Application Reference: 2026/0093

Site Address: 24 Dove Road, Wombwell, Barnsley, S73 0TE

This application seeks full planning permission for the erection of a single storey front extension to dwelling.

PROPOSED: GA PLANS ELEVATIONS	SCALE: 1:50 1:50
-------------------------------------	------------------------

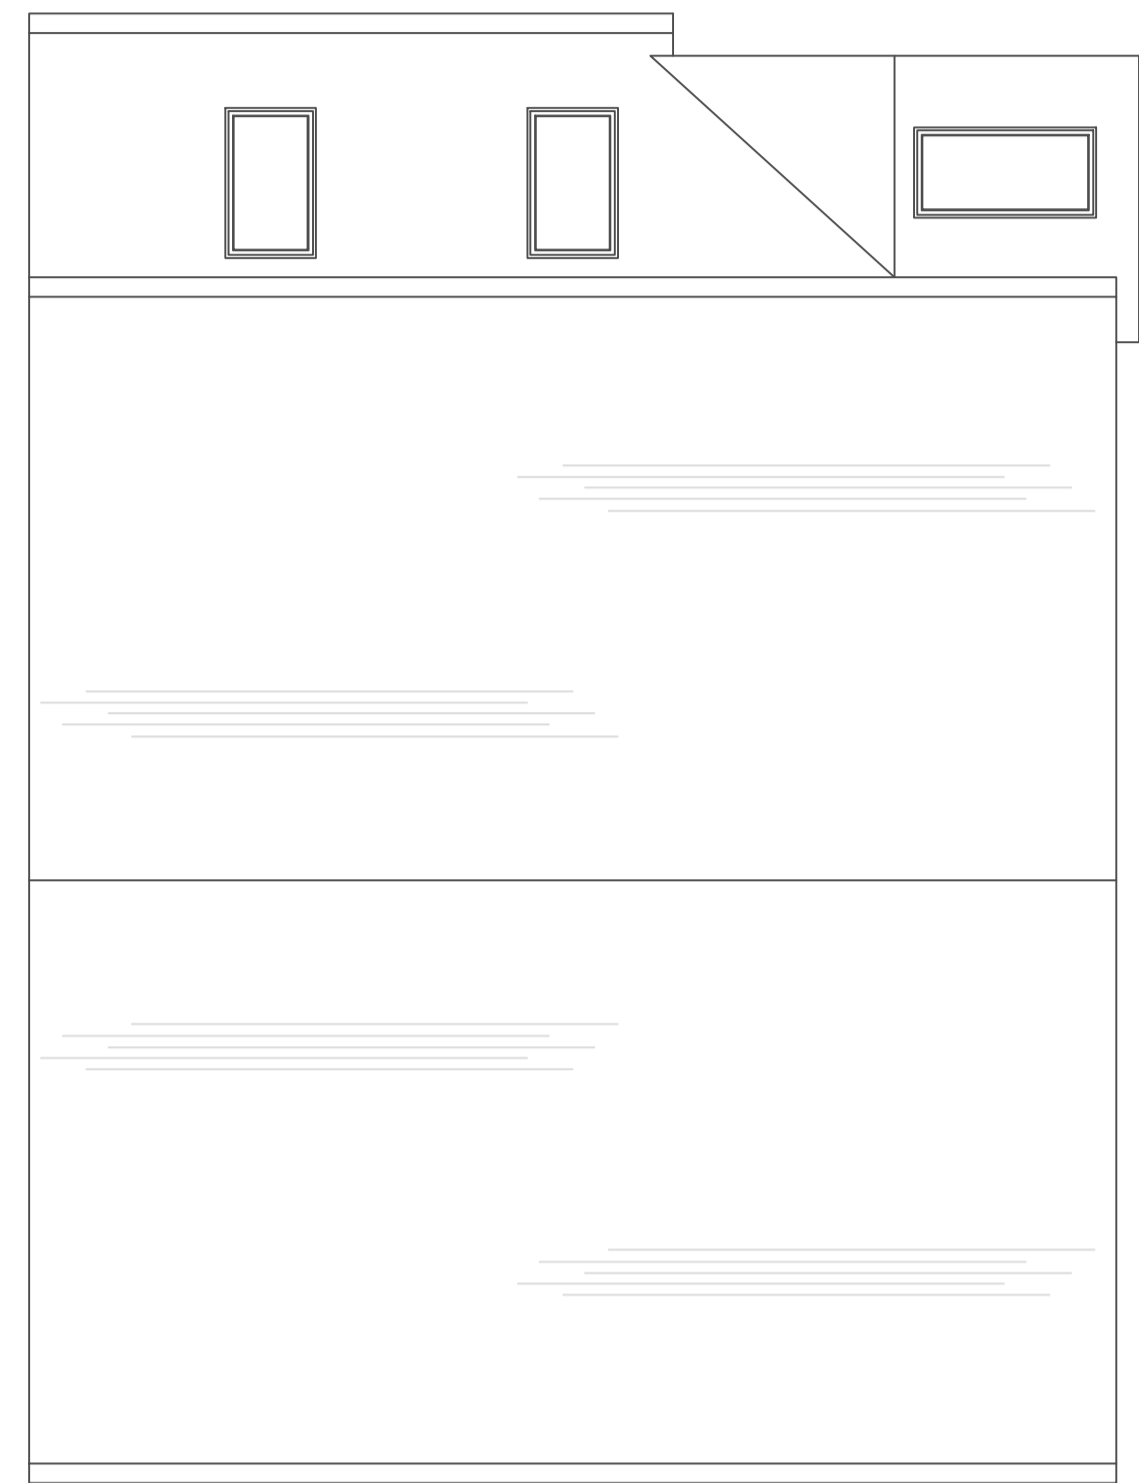
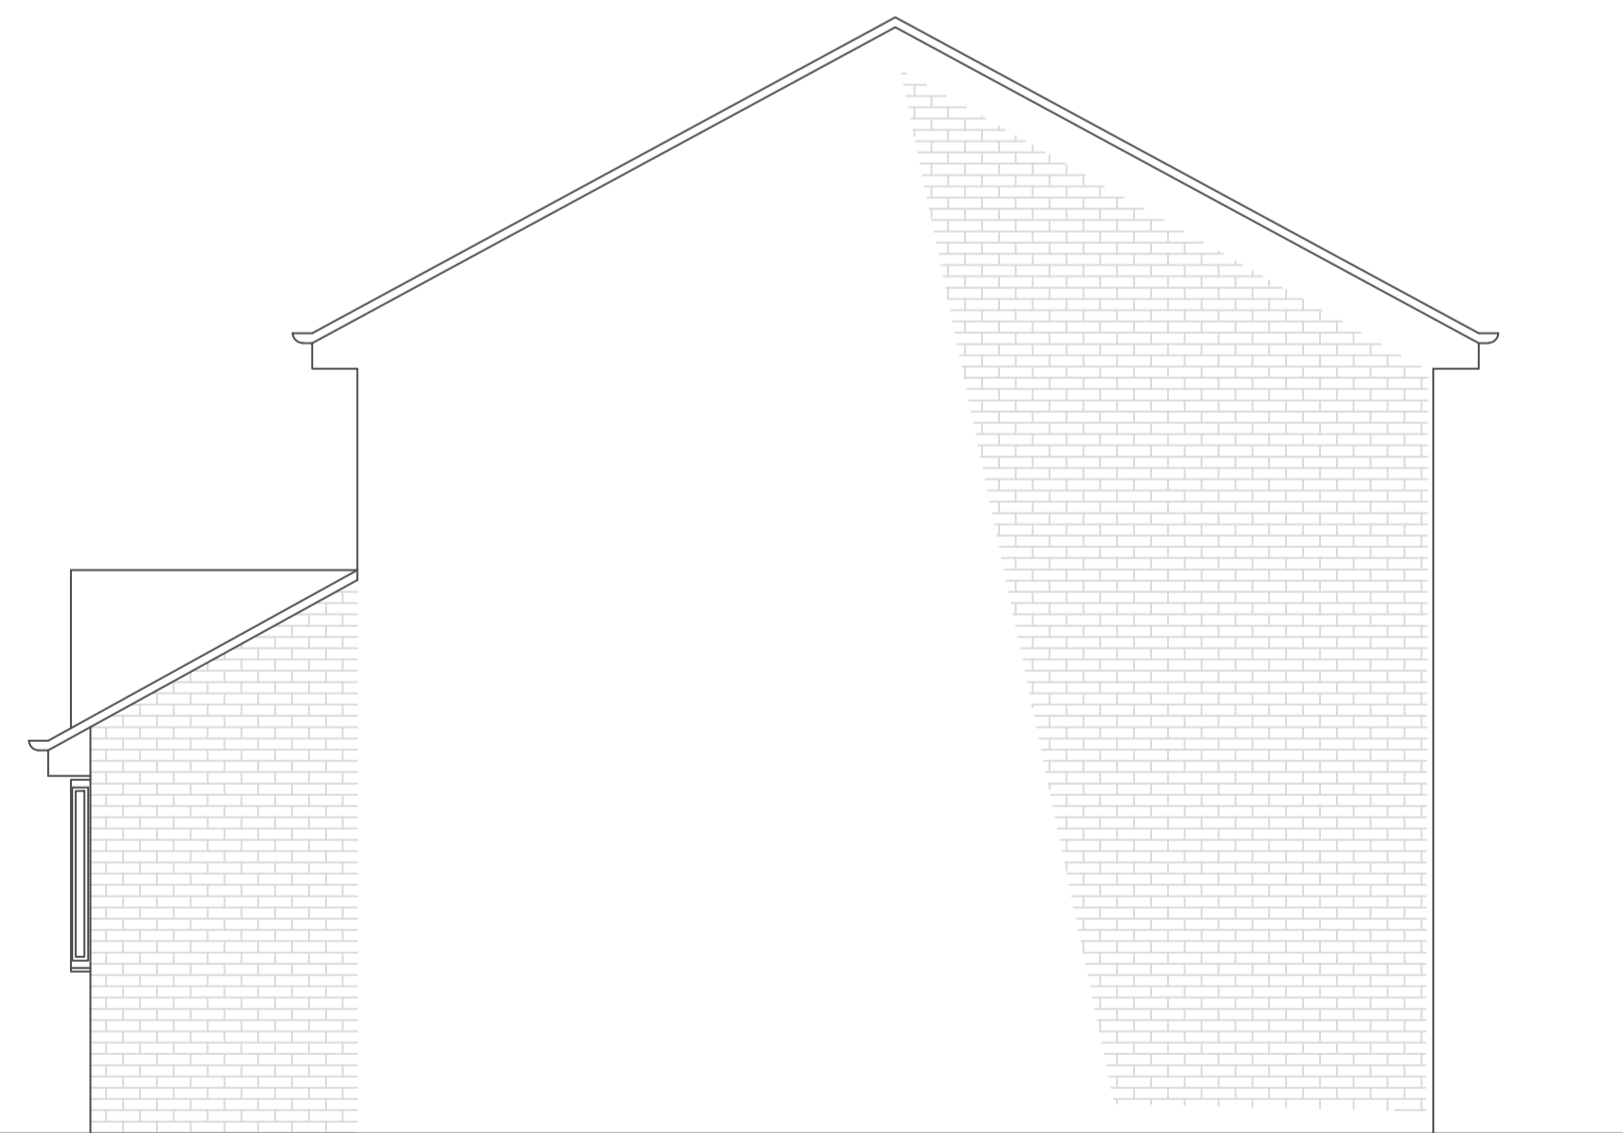
The proposed front extension is small in scale and will continue the building line across the front of the property. This type of development is commonplace within the immediate locality, resulting in the proposal harmonising not only with the host property but also within its surroundings. The matching materials, new bay window and design of the roof will ensure the proposal compliments the host property.

The proposed extension will project 1.7m to the front of the property in line with the existing forward projection. The neighbours on each side have existing front extensions similar to the proposal. There are no side facing windows on the neighbours extensions nor on the proposal. The property is detached, and it is noted that there is a reasonable gap in-between the properties. Overshadowing and loss of privacy from the proposed front extension is not expected to occur and is therefore not considered to be detrimental to the amenity currently enjoyed by the adjoining neighbours.
